Consultation Response from: KC Environmental Health (Pollution & Noise Control)

2025/90487 - 47 Huddersfield Road, Mirfield, WF14 8AE

Change of use and alterations to convert from vacant bank (Class E) to hot food takeaway (sui generis) with installation of extract and ventilation equipment and external alterations to the front and rear elevations

**Responding Date:
18 March 2025**

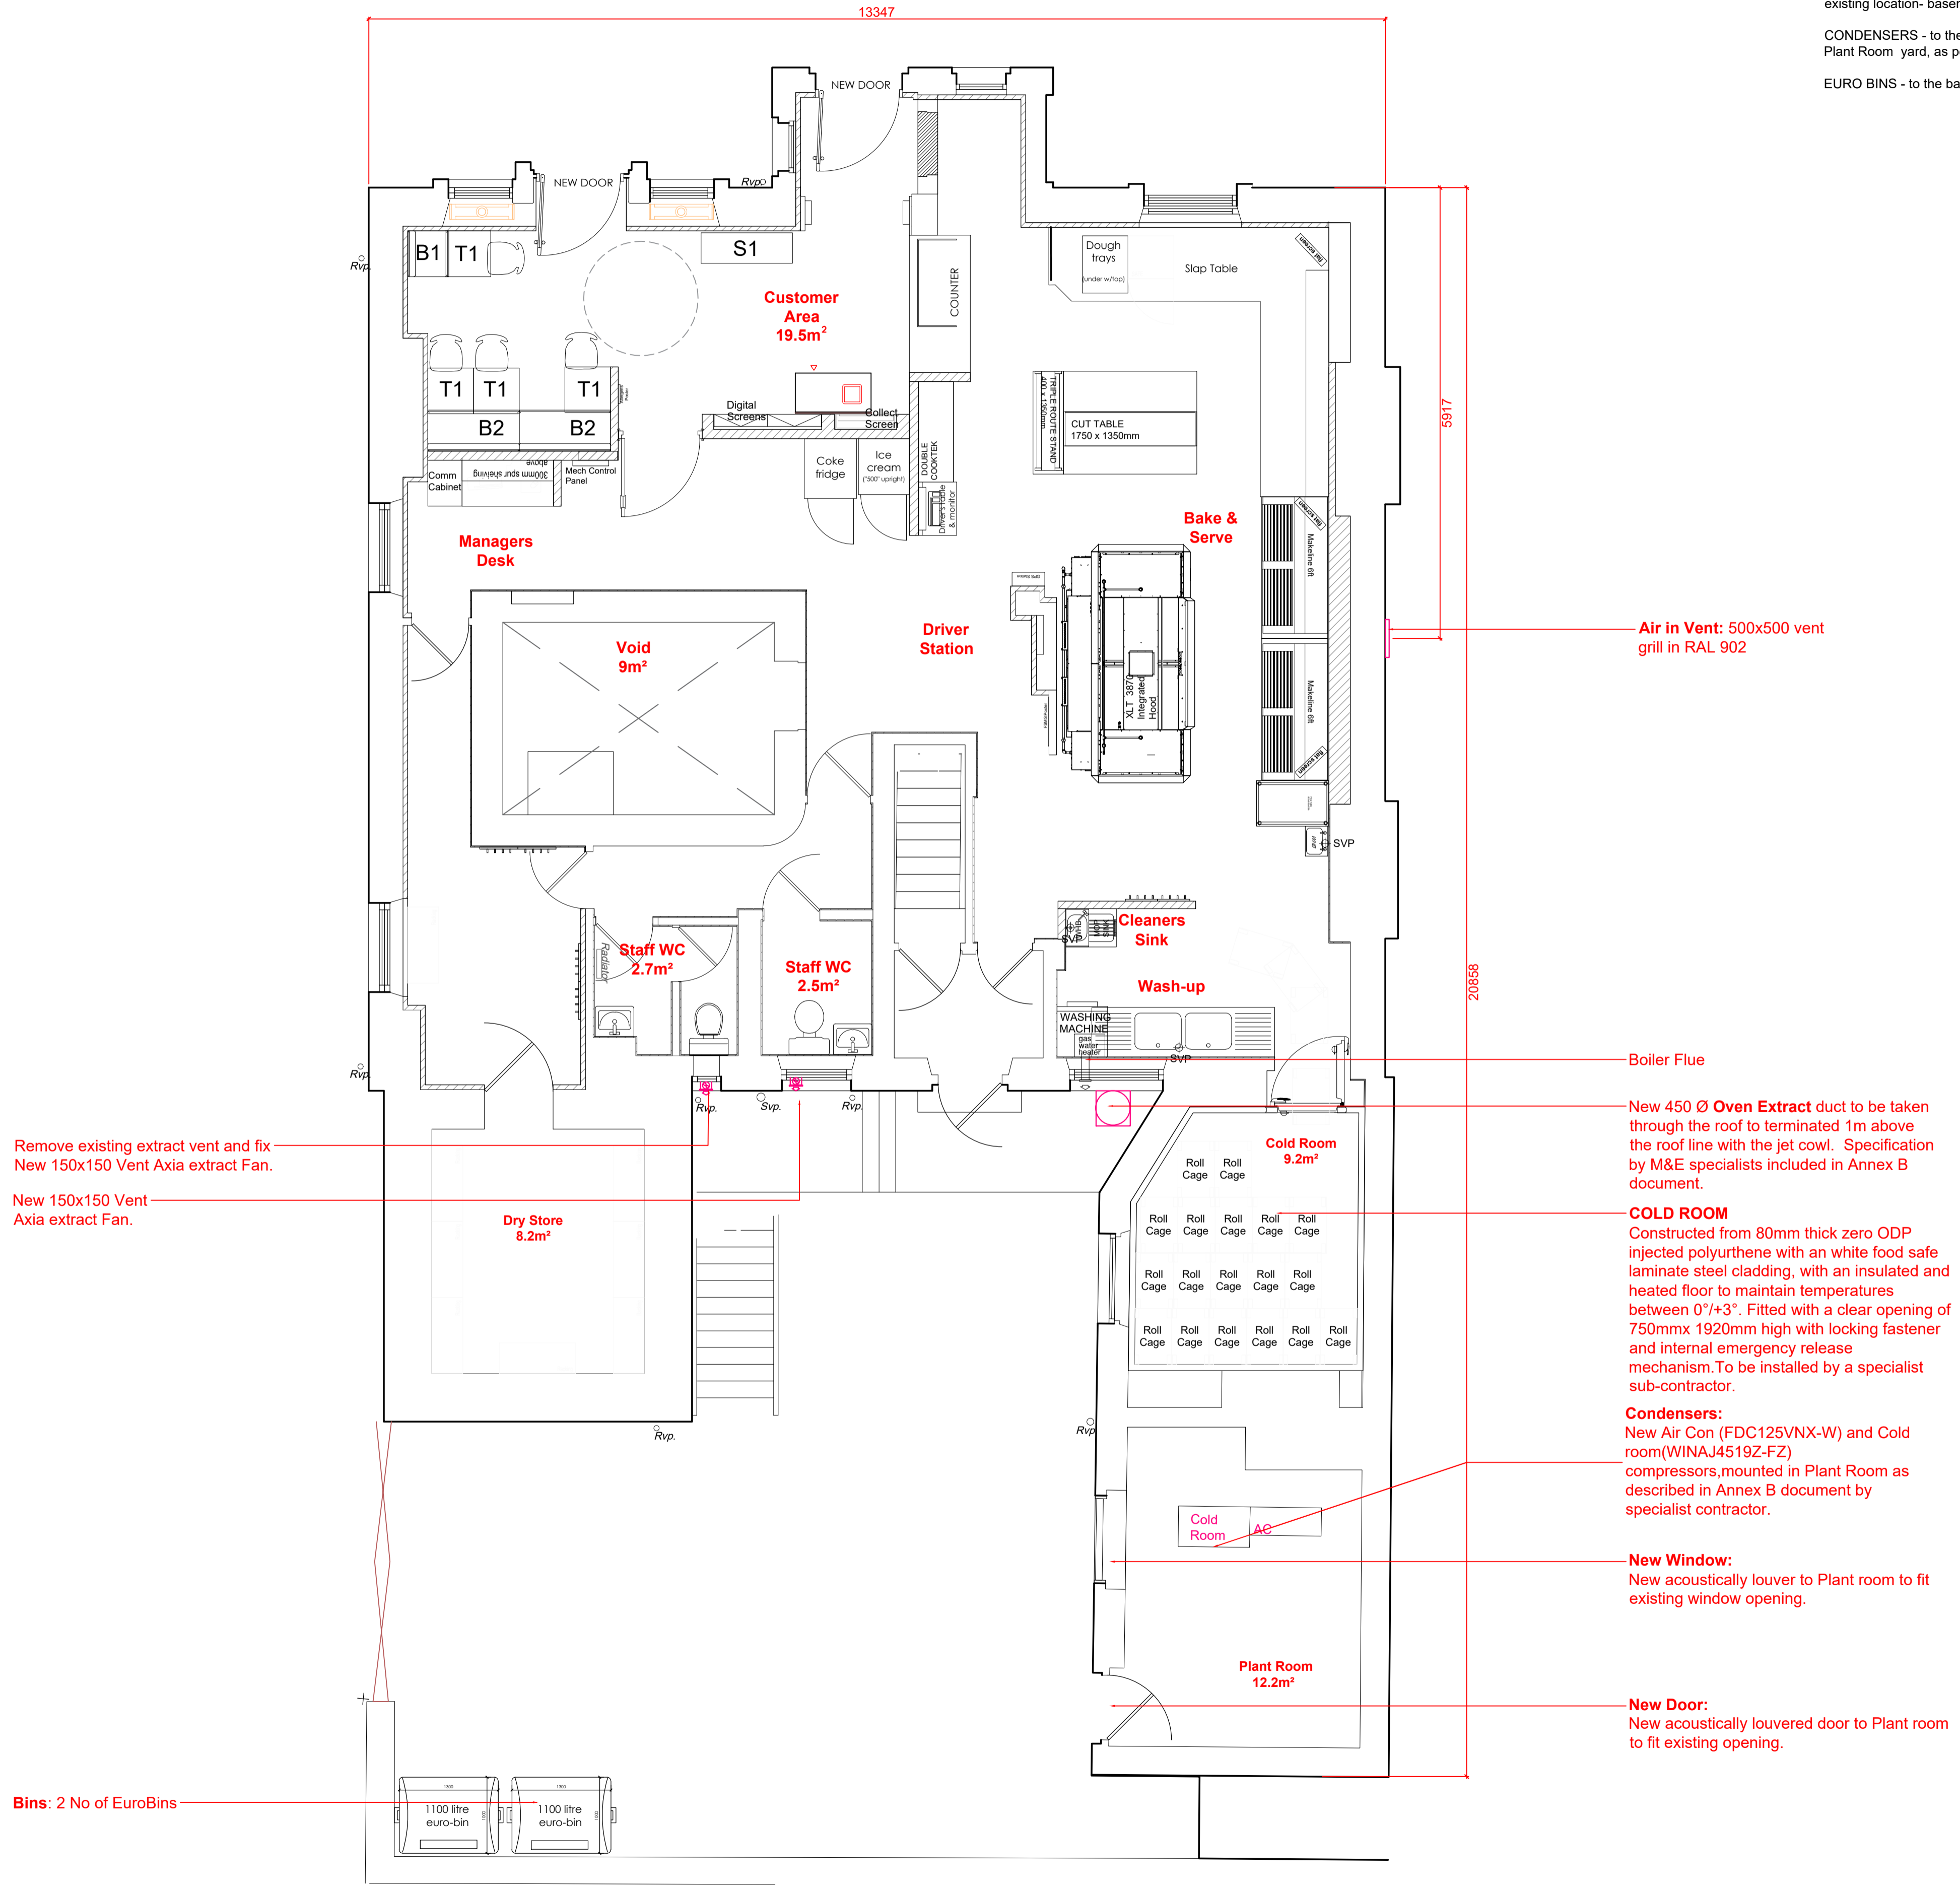
The first floor use will remain as residential and a higher level of sound insulation is required where residential and commercial uses share a party wall/floor/ceiling. No information is provided so a condition is recommended for the submission of a sound insulation test to show it meets with this requirement.

Before the development is brought into use written evidence to demonstrate that the airborne sound insulation performance of the party floors/walls/ceiling of the development is of a minimum of 53dB $D_{nTw} + C_{tr}$ shall be submitted to and approved in writing by the Local Planning Authority. If it cannot be demonstrated that the aforementioned airborne sound insulation performance has been achieved, a scheme incorporating further measures to achieve the sound insulation performance shall be submitted to and approved in writing by the Local Planning Authority. All works comprised within those further measures shall be completed and further written evidence to demonstrate that the aforementioned sound insulation performance level has been achieved shall be submitted to and approved in writing by the Local Planning Authority before the development is first brought into use.
